Our ref: OUT26/2171

Subject: Garoo Solar Farm (SSD-79747209) – Environmental Impact Statement

Detailed advice to DPHI Planning & Assessment regarding the Garoo Solar Farm (SSD-79747209) – EIS

DRAWING: Preliminary & Conceptual Creek Bridge Layout

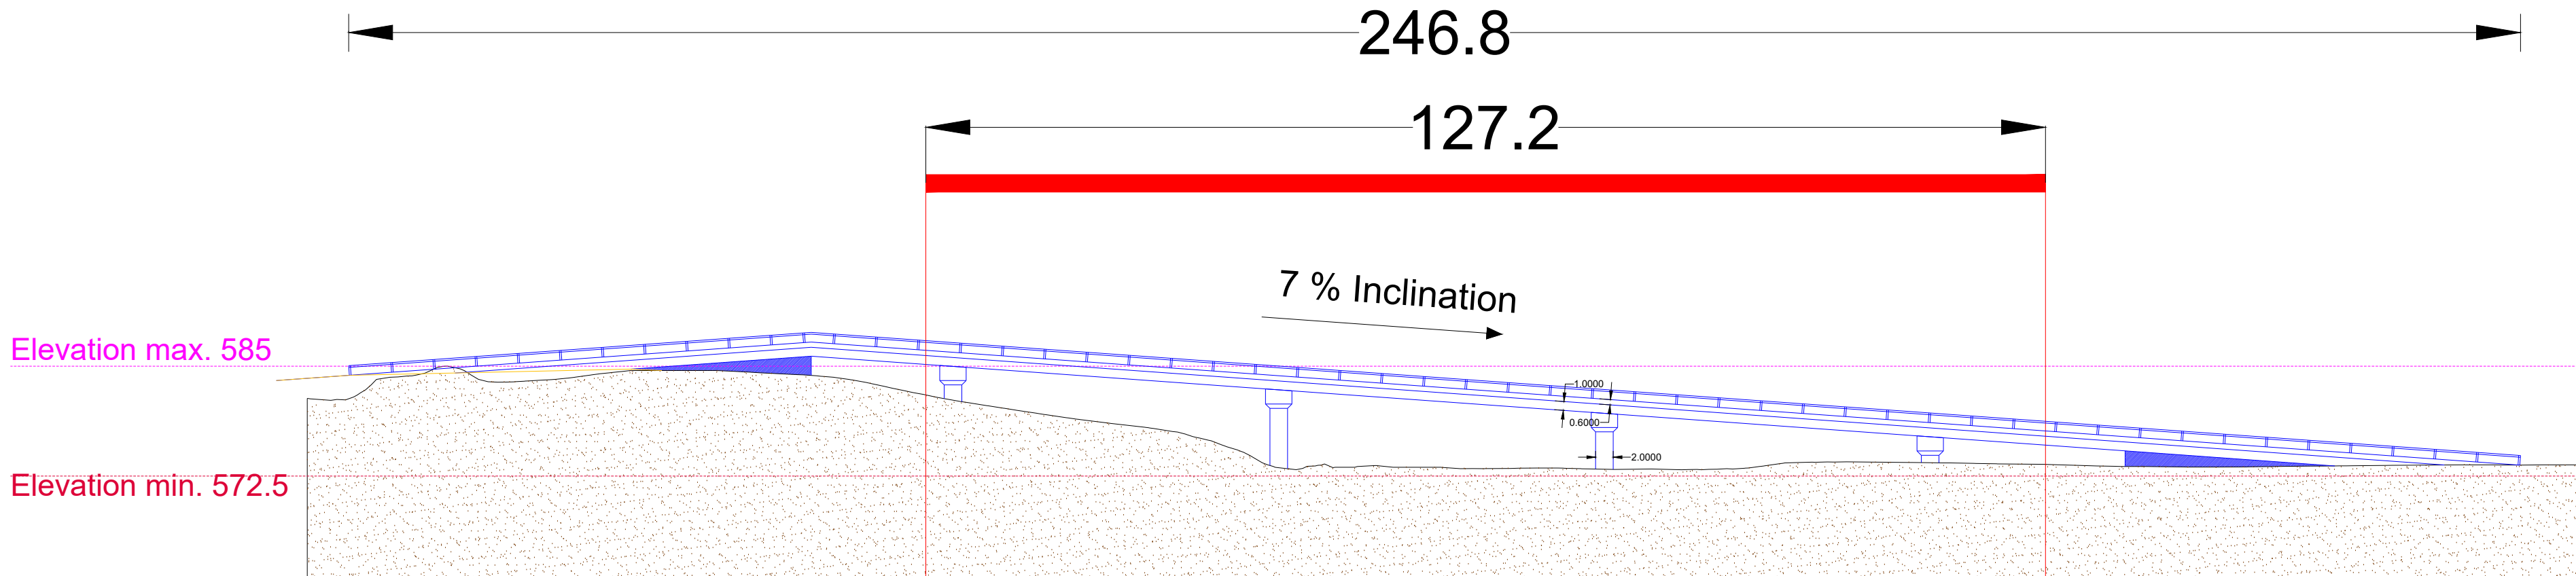
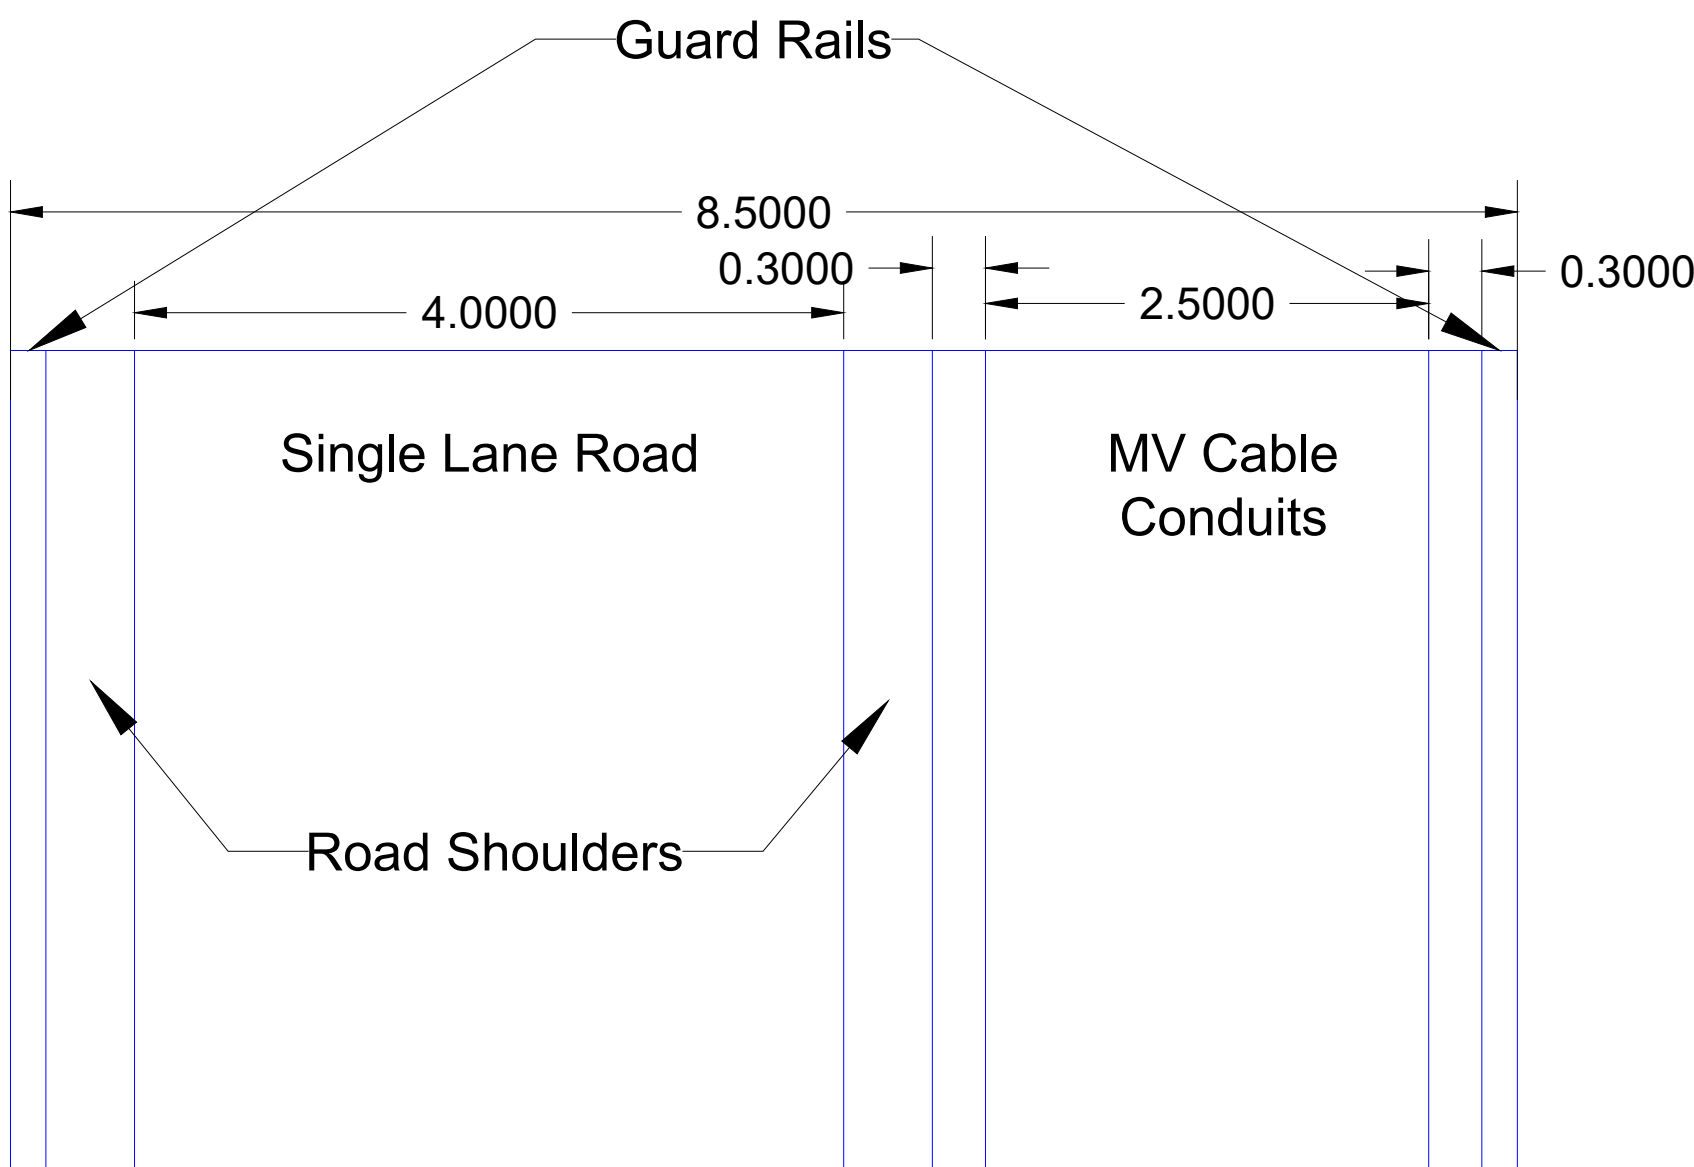
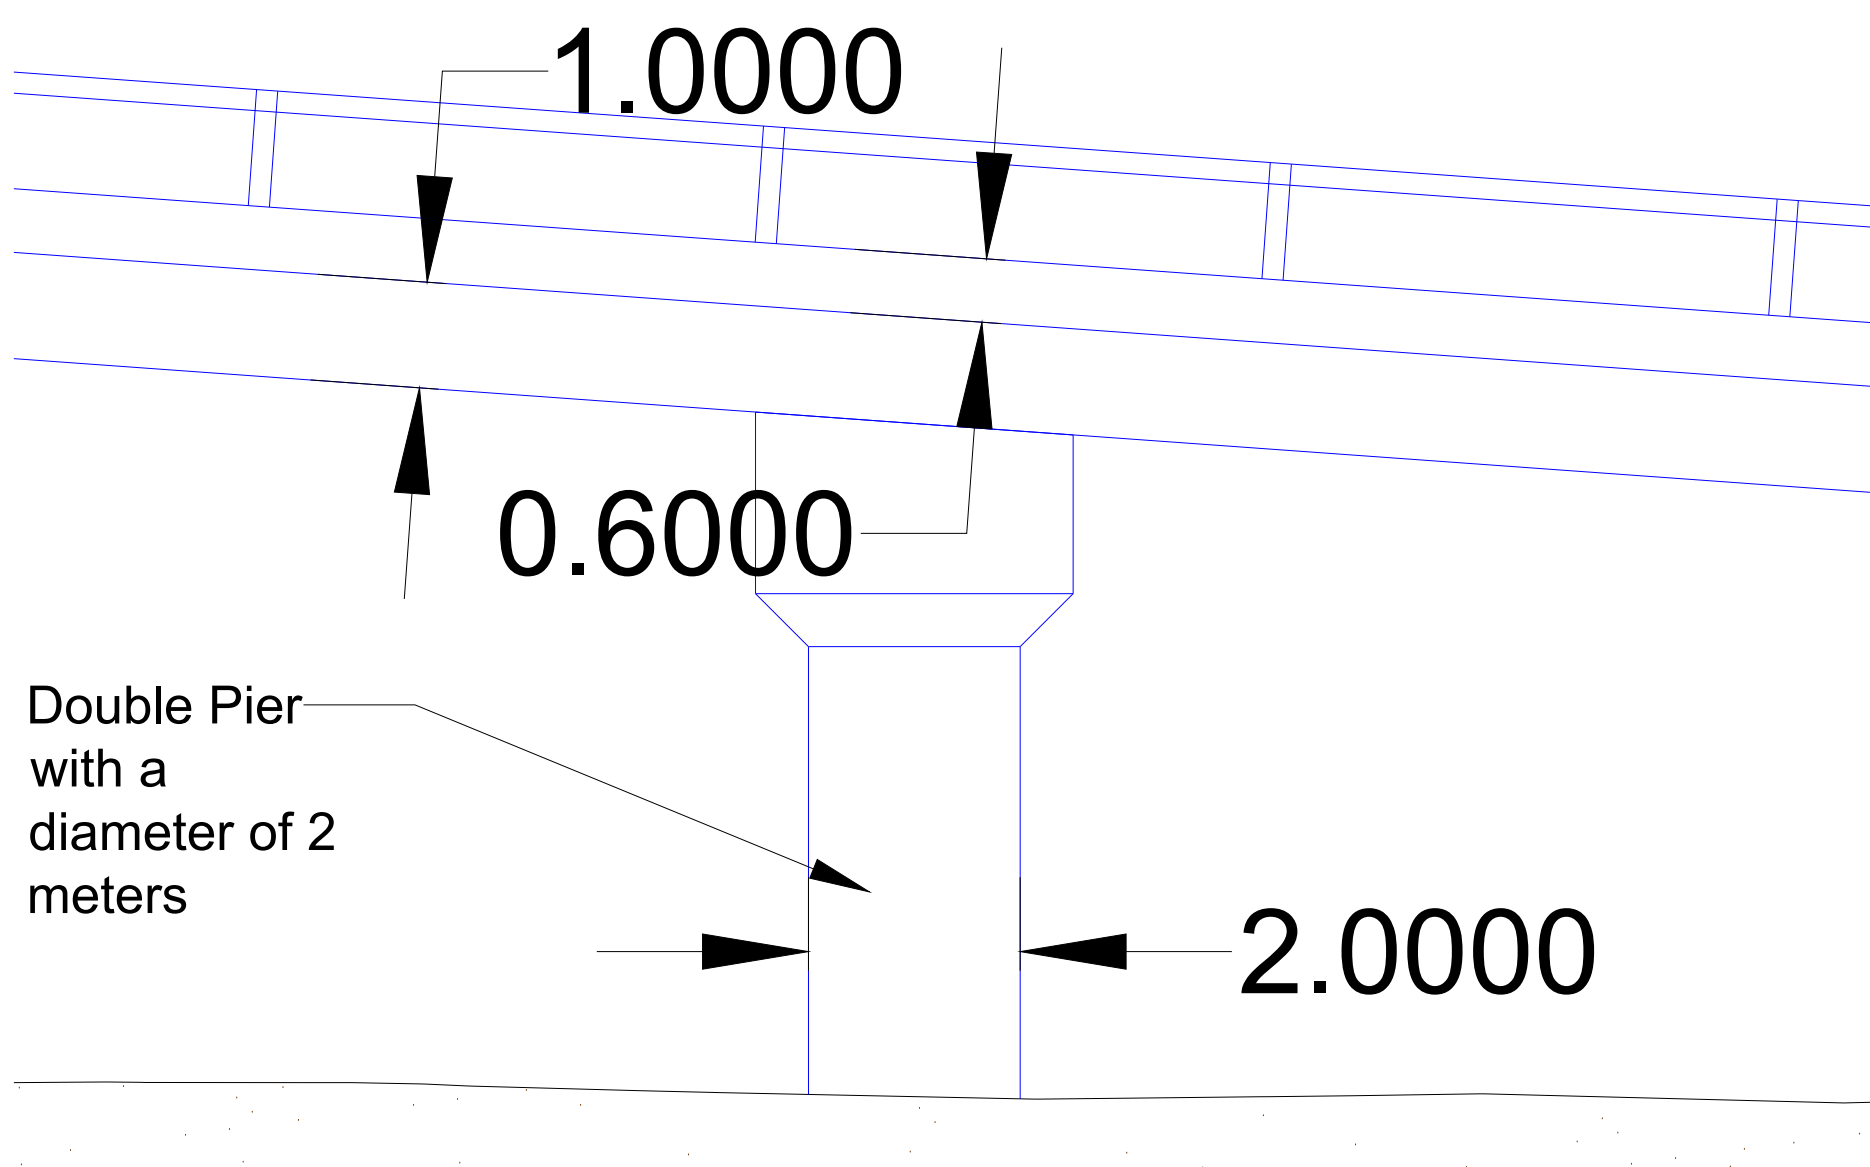
Works on waterfront land are required for the project which include but is not limited to the design and construction of the crossing over Tamarang Creek and other watercourse crossings. The Guidelines for Controlled Activities on Waterfront Land (DCCEEW 2025) is a relevant guideline that needs to be addressed.

DPHI requests the proponent to ensure works on waterfront land are designed, constructed and maintained in accordance with the Guidelines for Controlled Activities on Waterfront Land (DCCEEW 2025).
